From: Breezie Allwright <Breezie.Allwright@arun.gov.uk> **On Behalf Of** Planning
Sent: 01 September 2026 10:15
To: Planning.Responses <Planning.Responses@arun.gov.uk>
Subject: Fw: Planning application BN/87/26/HH

From: Anthony W [REDACTED]
Sent: 27 August 2026 15:30
To: Planning <Planning@arun.gov.uk>
Subject: Planning application BN/87/26/HH

I would like to put a objection in regards this planning application for a fence between the driveways where I live at 39 Hedge End, Barnham, And 38 Hedge end, Barnham.

PROPOSED FENCE ELEVATION	REV A
38 HEDGE END BARNHAM	
CLIENT: MR & MRS BAGNELL	
SCALE 1:50 @ A3	
DRAWING N° PDW 1 HE	
REV B. Marked up fence length.

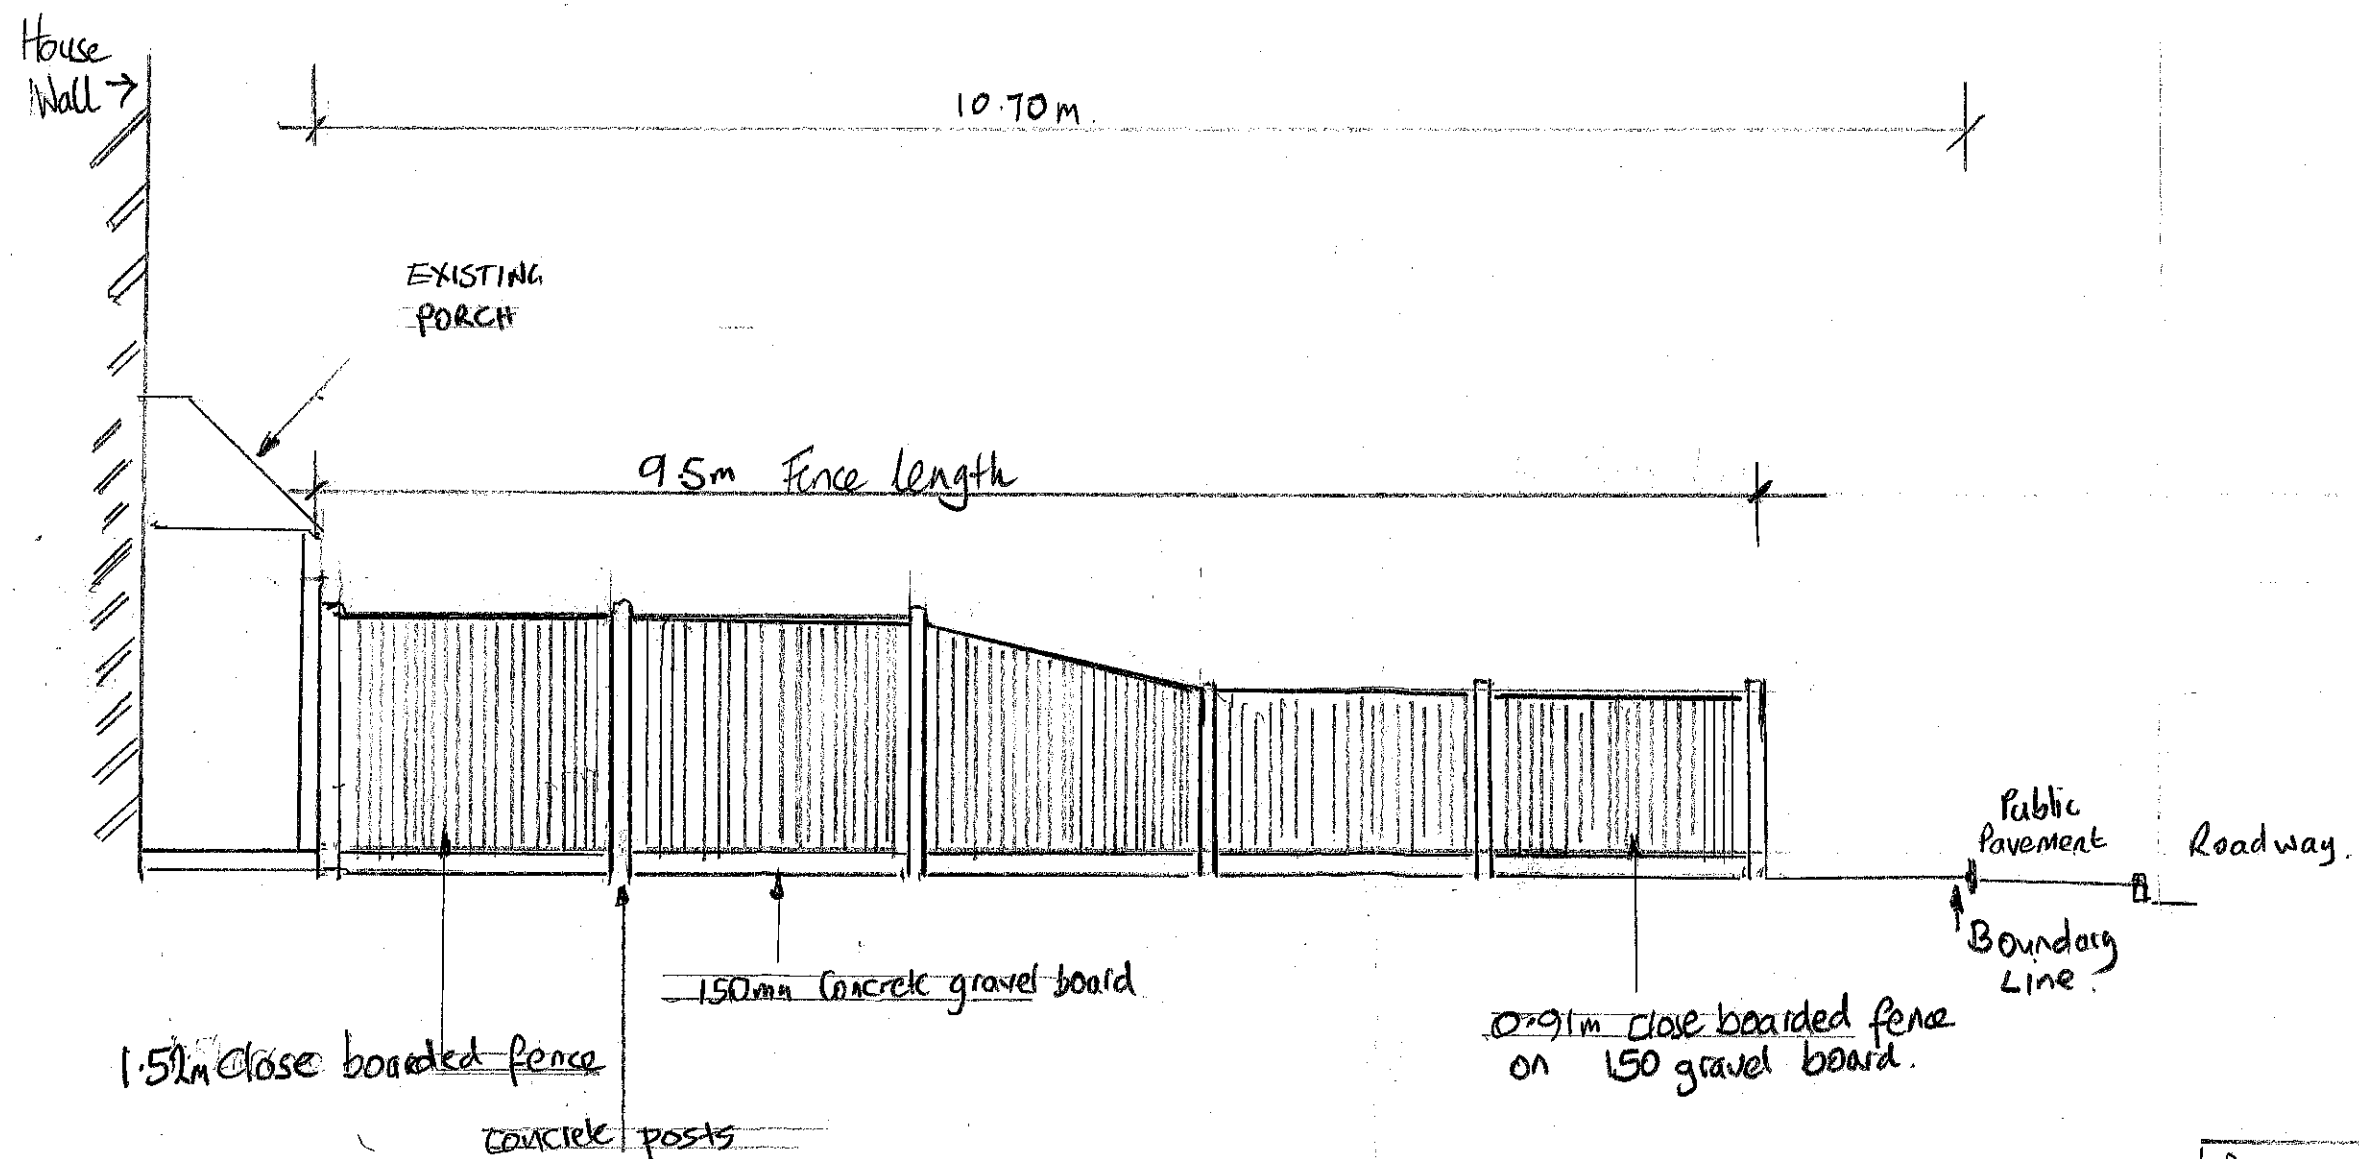
I feel having a fence along the drive will seriously hinder my view as I exit my drive, which could cause a dangerous situation as many children pass by our drive on the way to school. This fence would also cause great difficulty for my wife [REDACTED] as the driveways are very small.
